**Written representation by
First Corporate Shipping Limited
trading as The Bristol Port Company**

23 November 2020

**Application by North Somerset Council for an order granting development
consent for the Portishead branch line - MetroWest phase 1**

**Planning Inspectorate reference TR040011
Interested party reference PORT-S57657**

674946.BQ.42.01-385 E

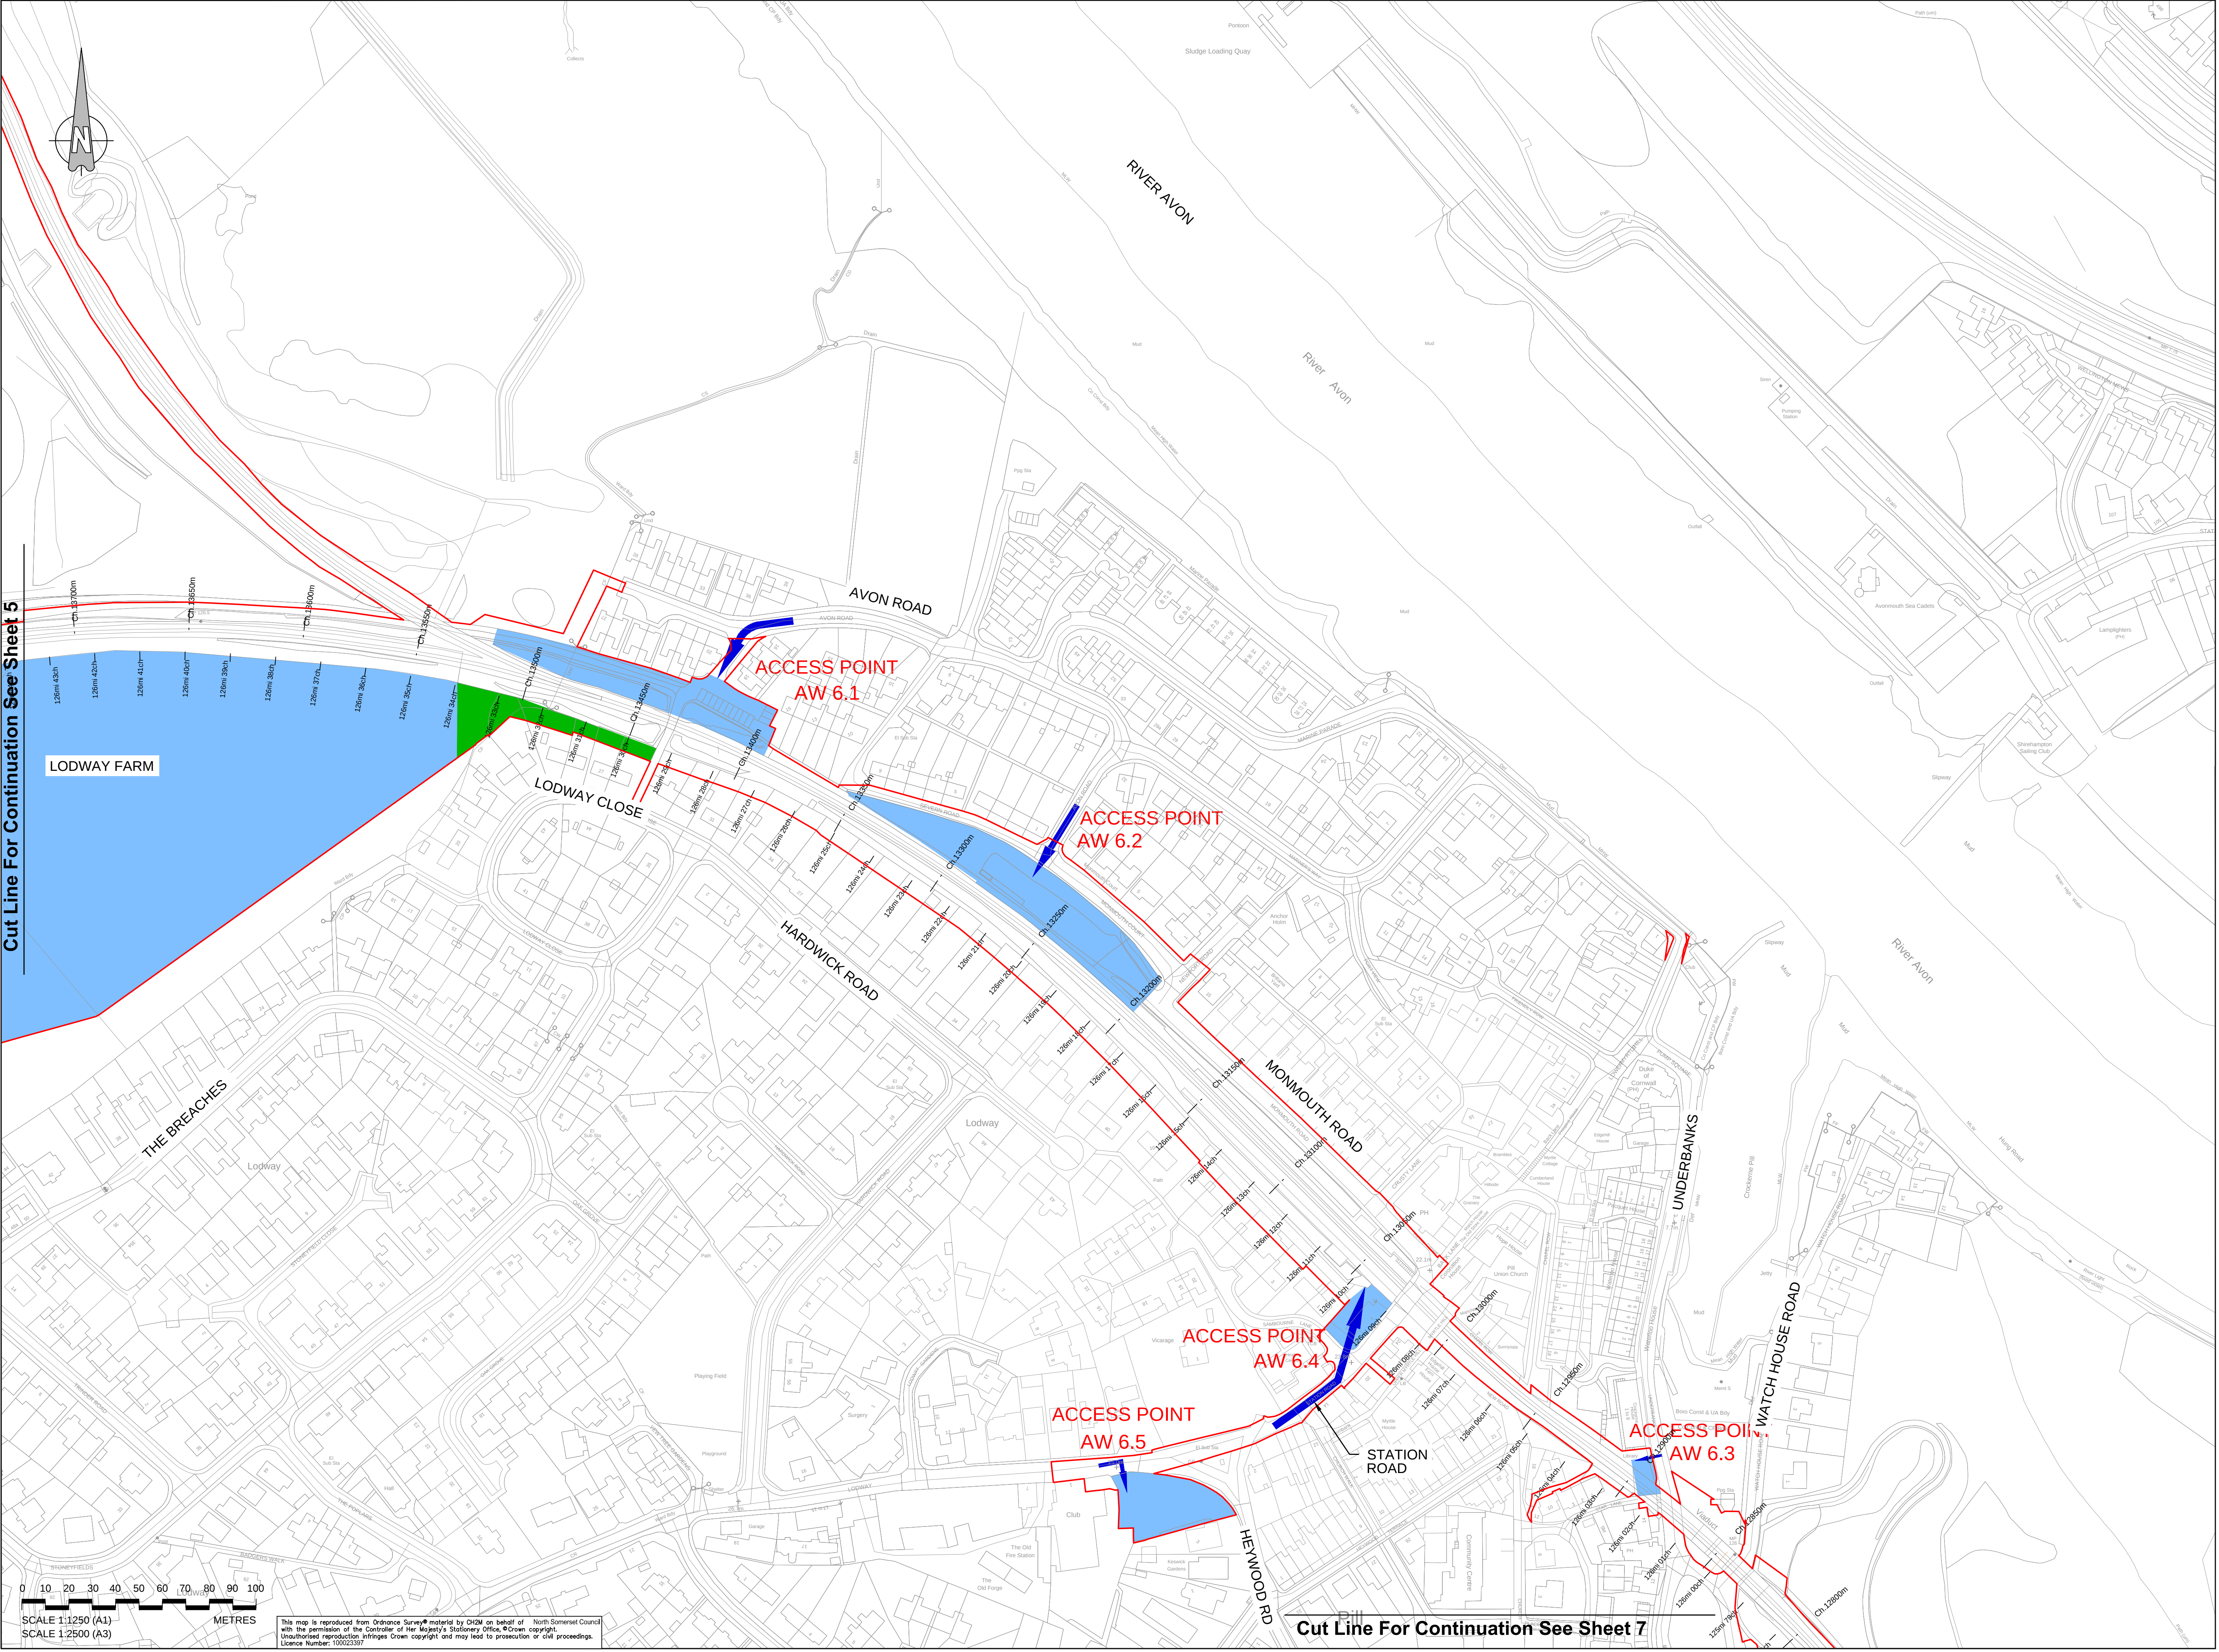
- 5.6 The draft DCO does not adequately protect BPC's rail paths or prevent interference with rail access for freight traffic to and from the Port during construction.
- 5.7 The proposed location of a construction compound on BPC land beneath the M5 overbridge will interfere with the need for access and impair the security integrity of the RPD Estate.
